26 November 2014

Letter of support - Lismore Base Hospital – Stage 3B

3 EASTERN ELEVATION
1:200

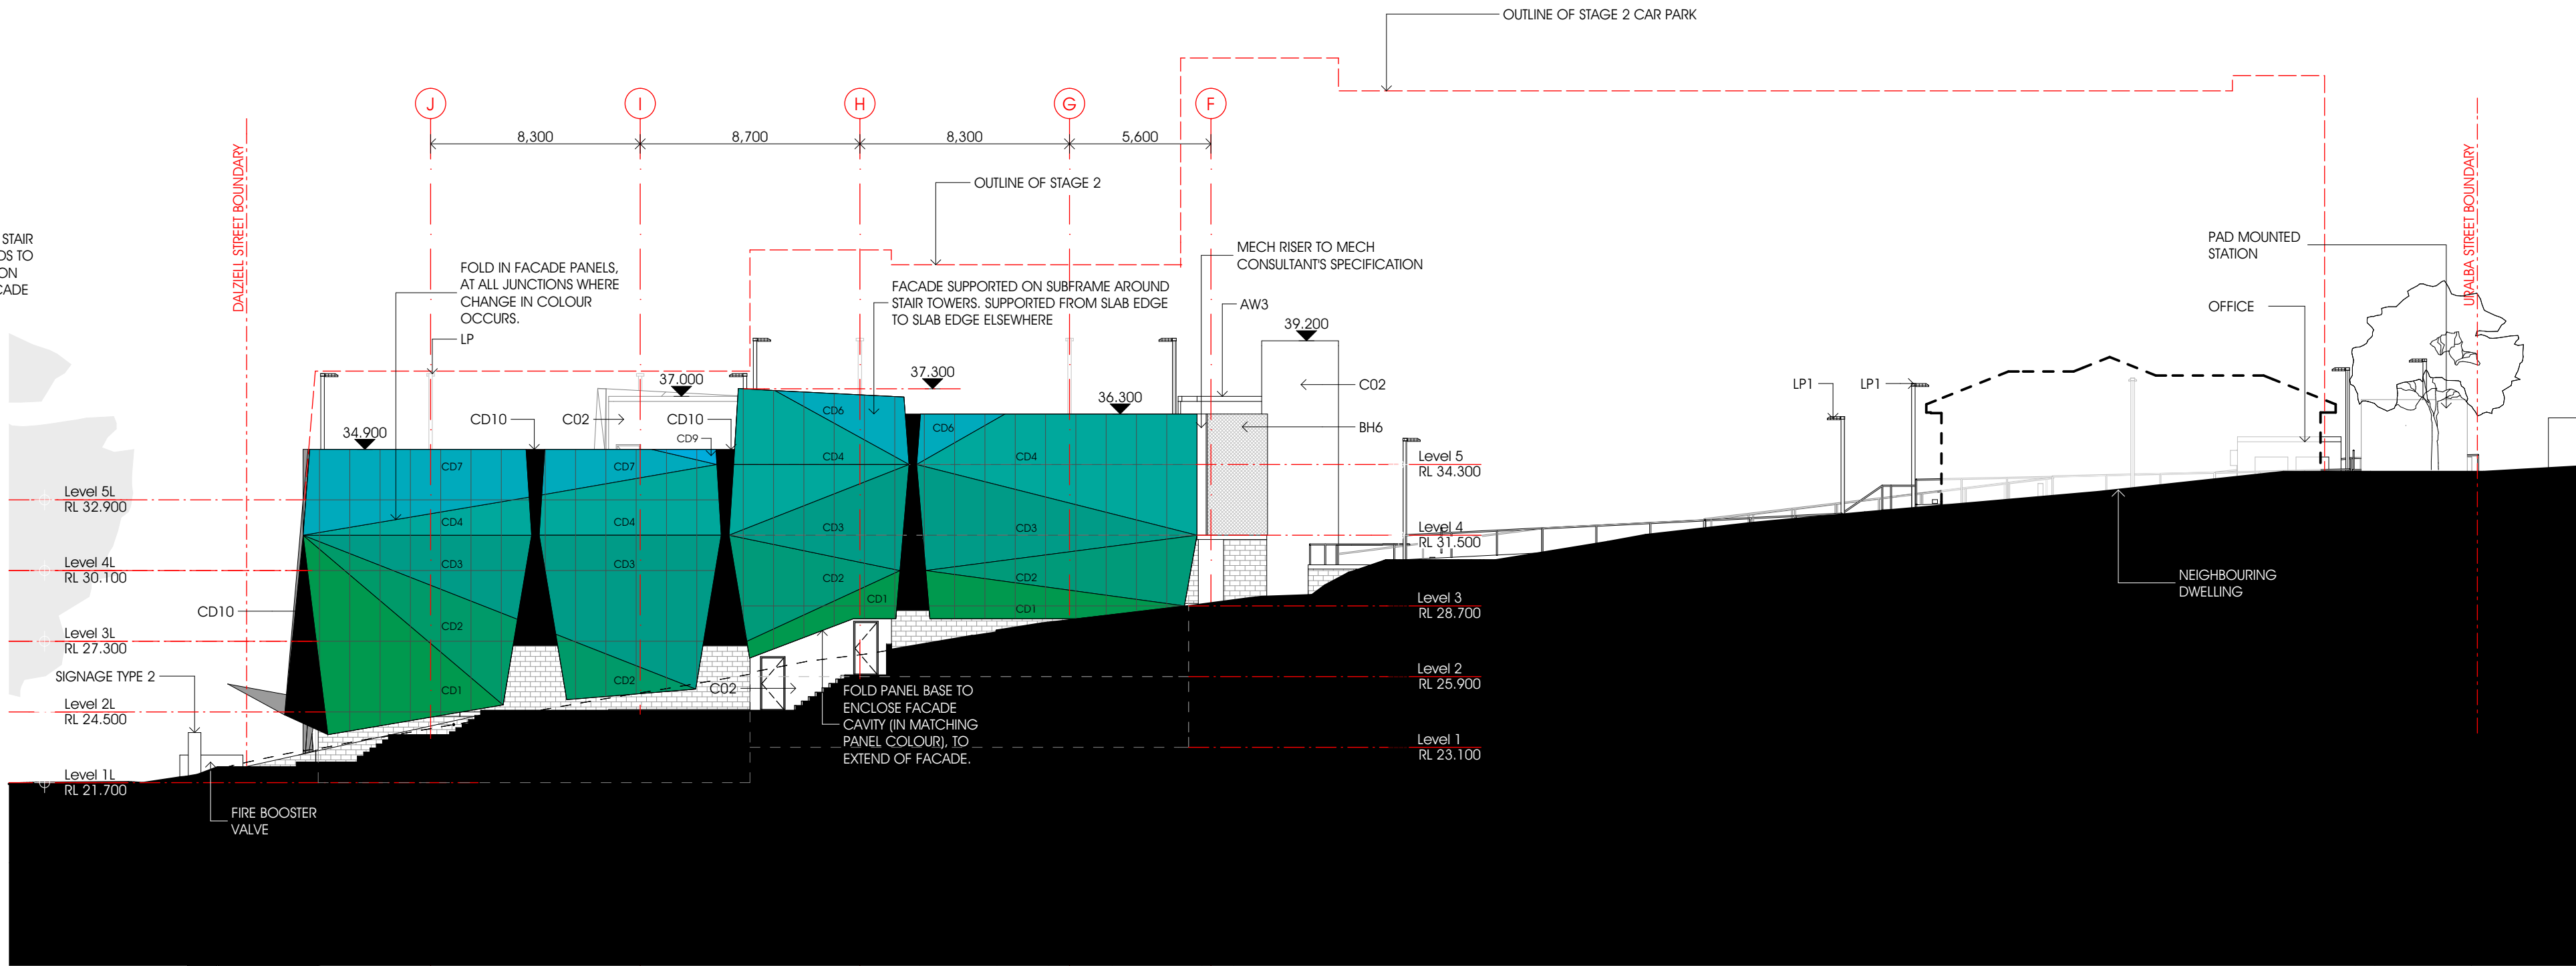
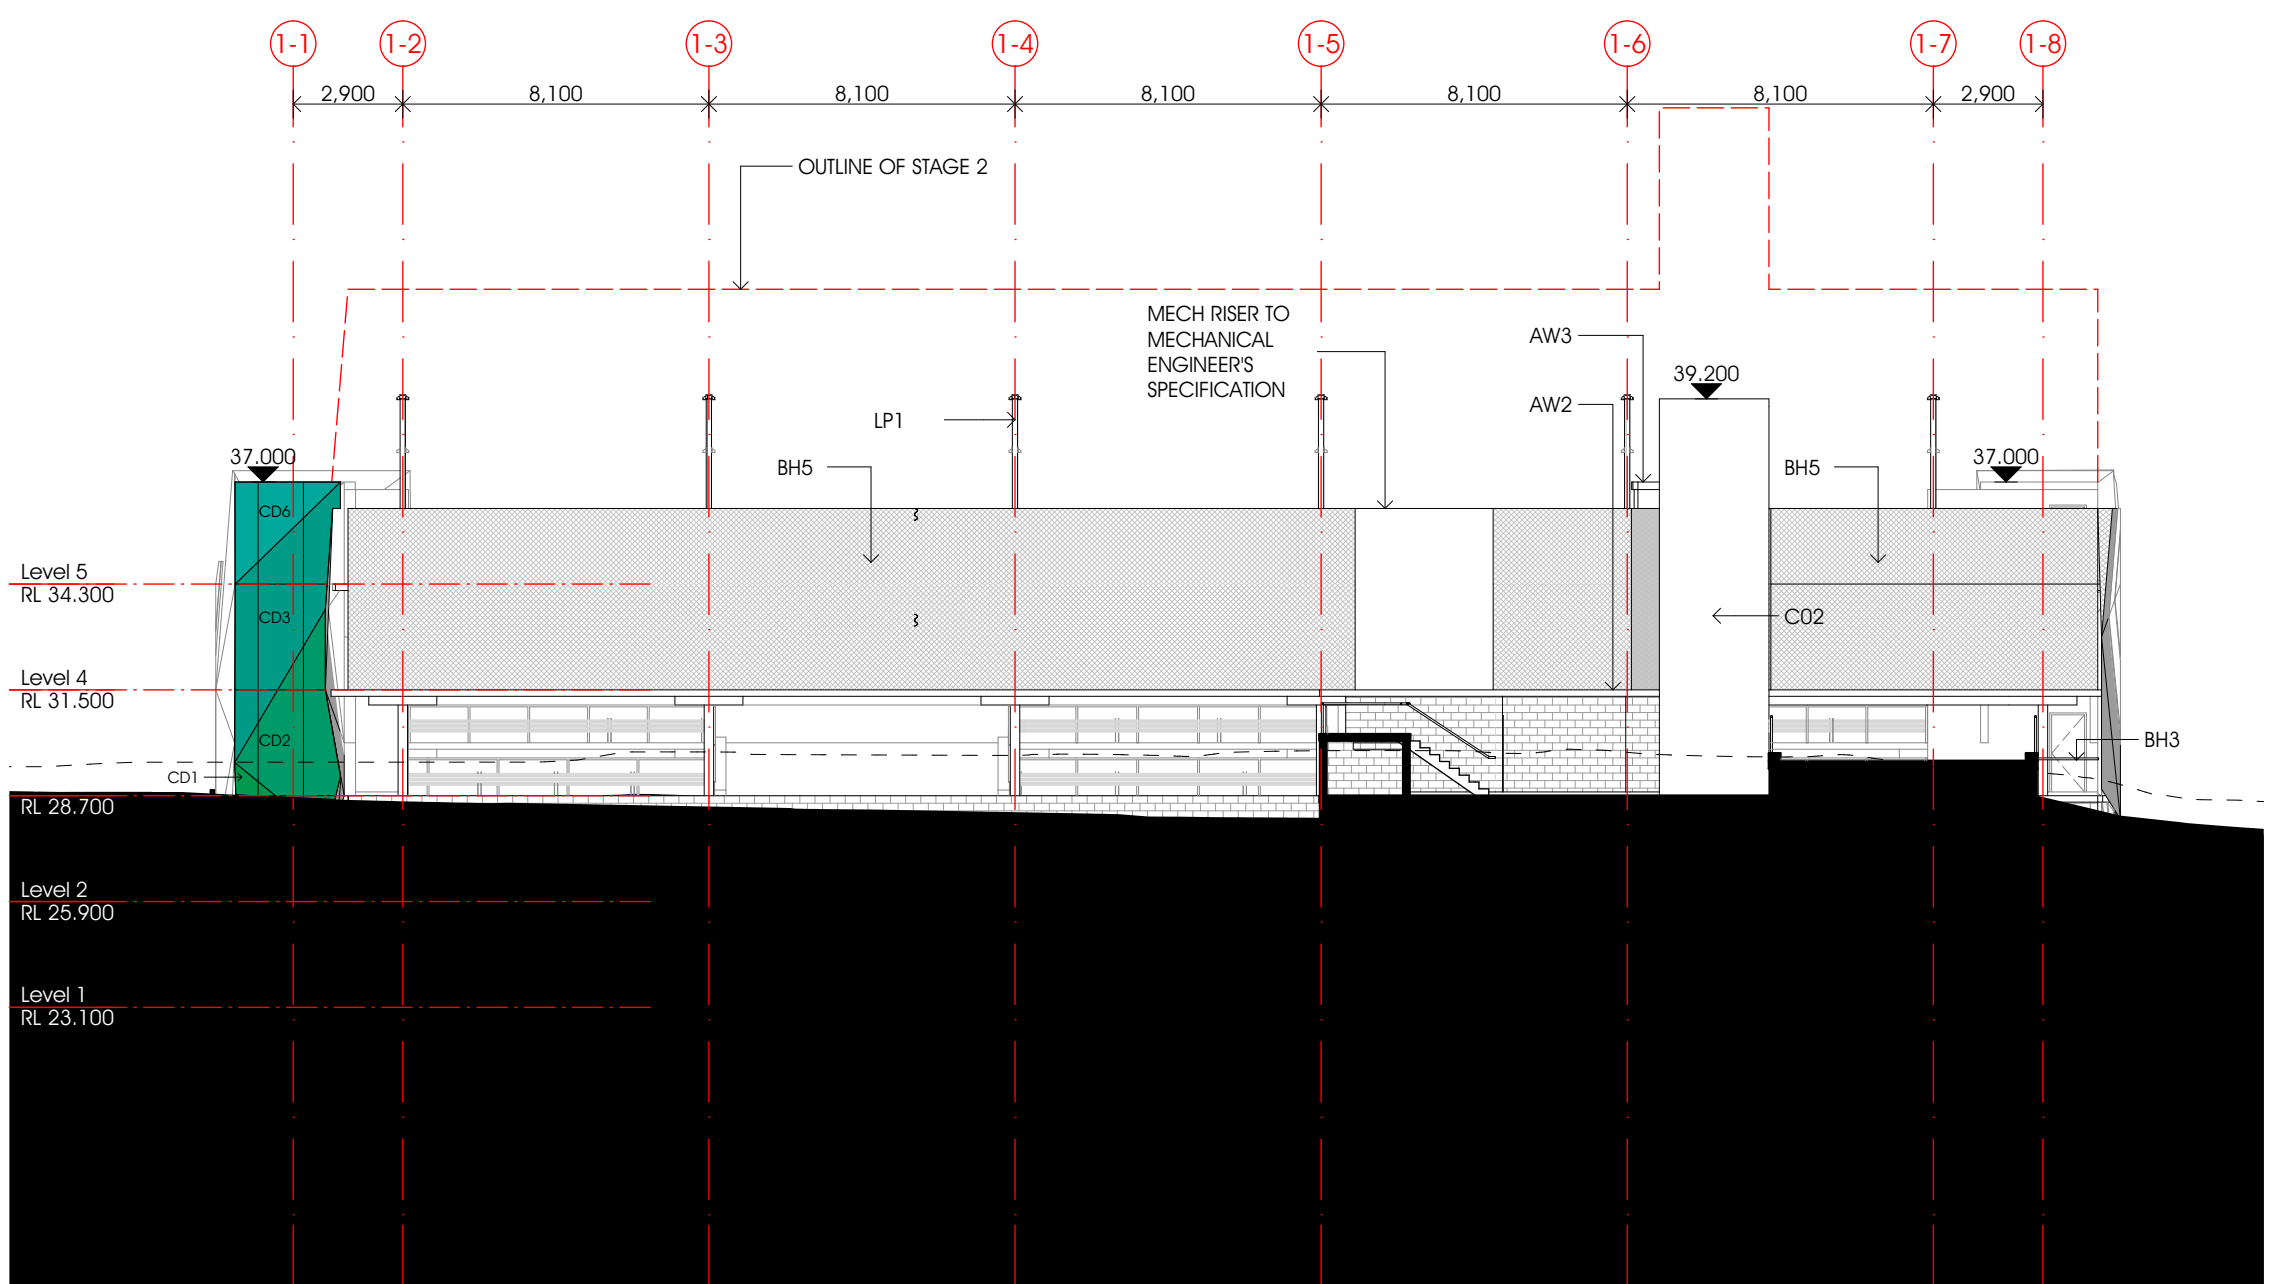
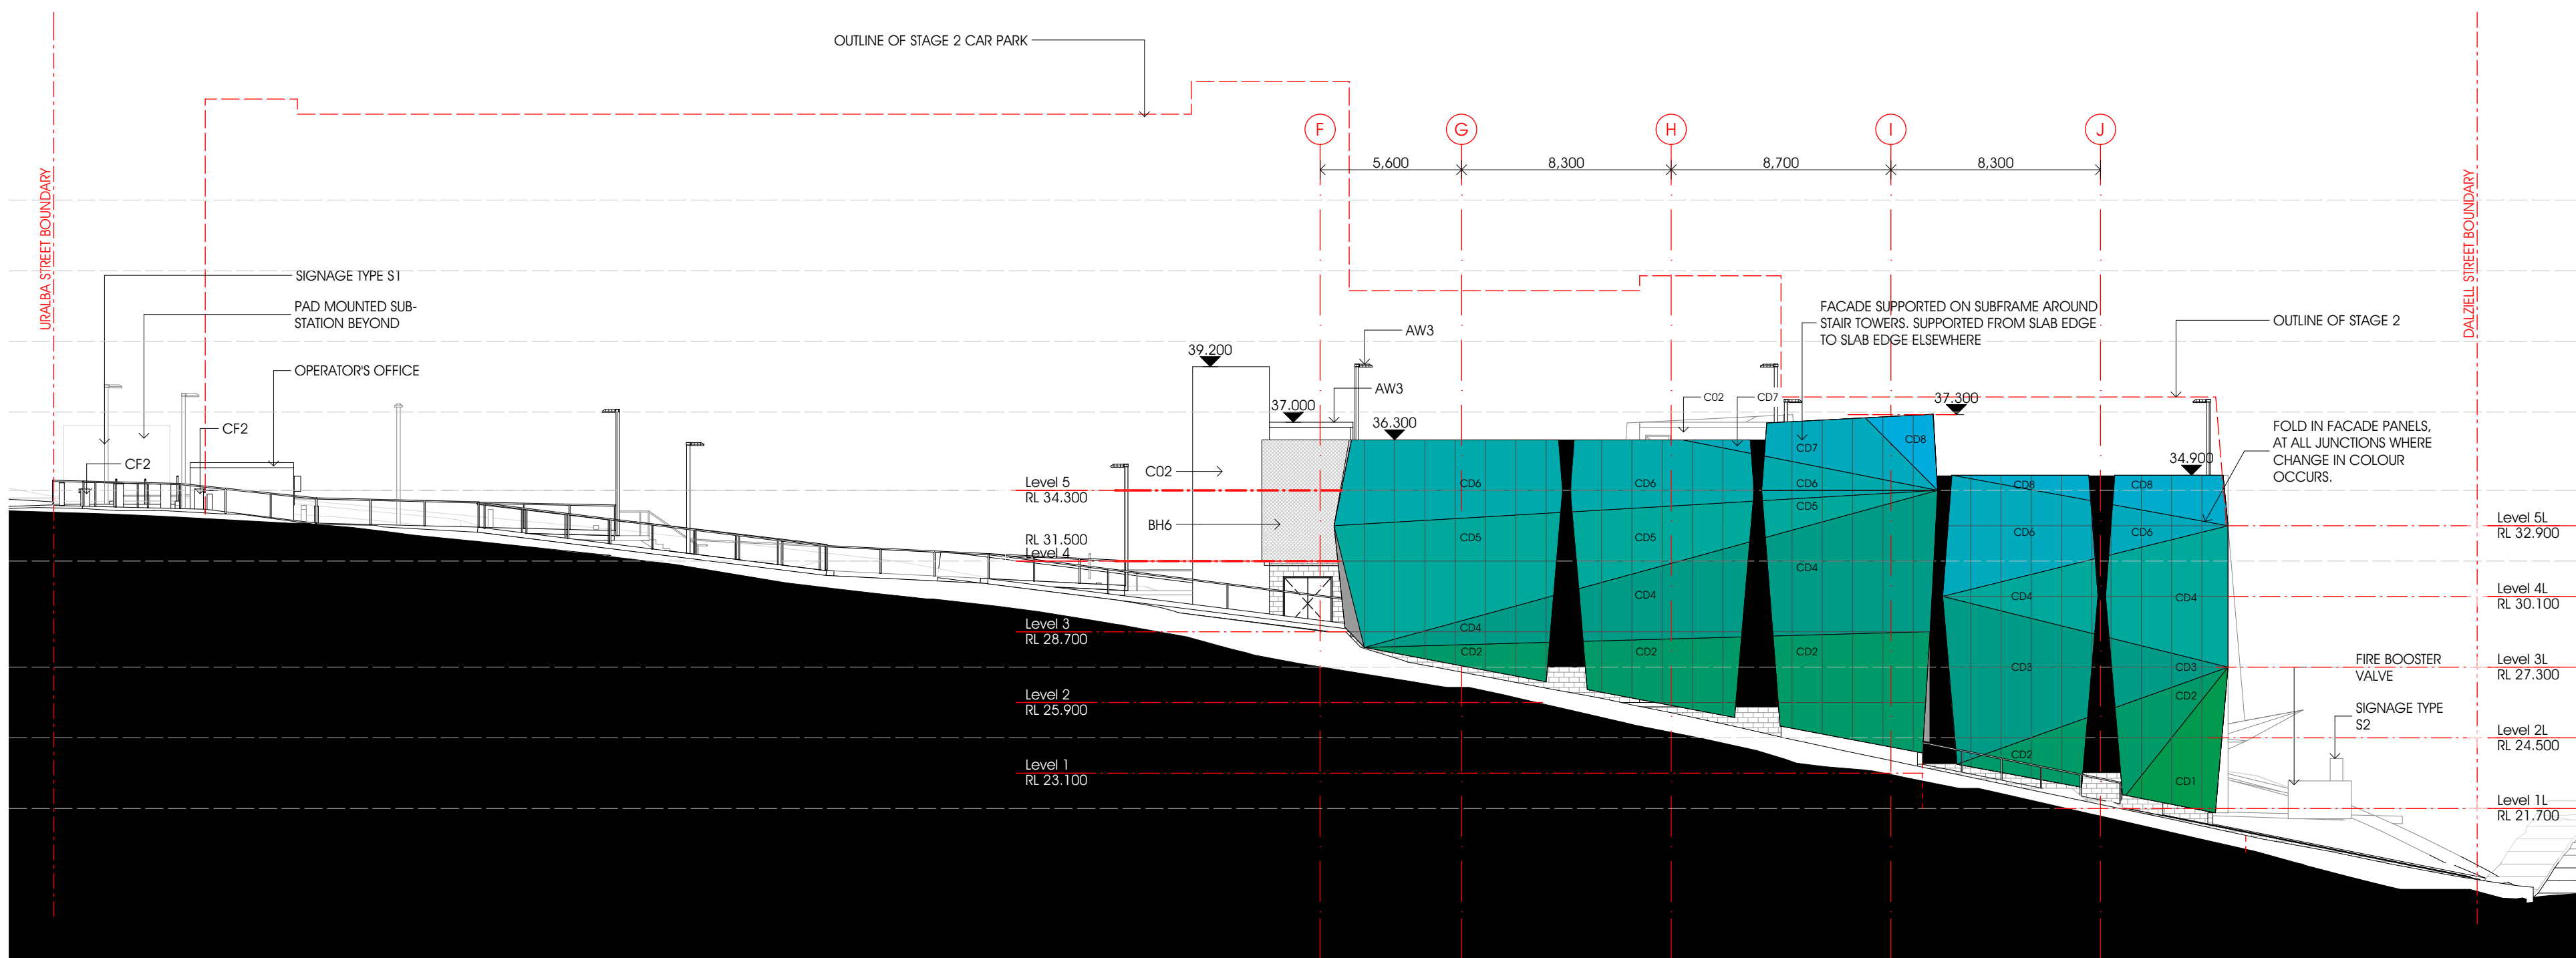
Council congratulates you on the 500 car parking station that you have proposed between Uralba Street and Dalziell Street. This facility will greatly improve the amenity of the residents who live in proximity to the Hospital and will serve well both the staff and visitors to the hospital. The cladding you propose for this car park will greatly assist in integrating this building into what is essentially a residential area and alleviate previous concerns about the possible visual impact of such a significant and important infrastructure facility.
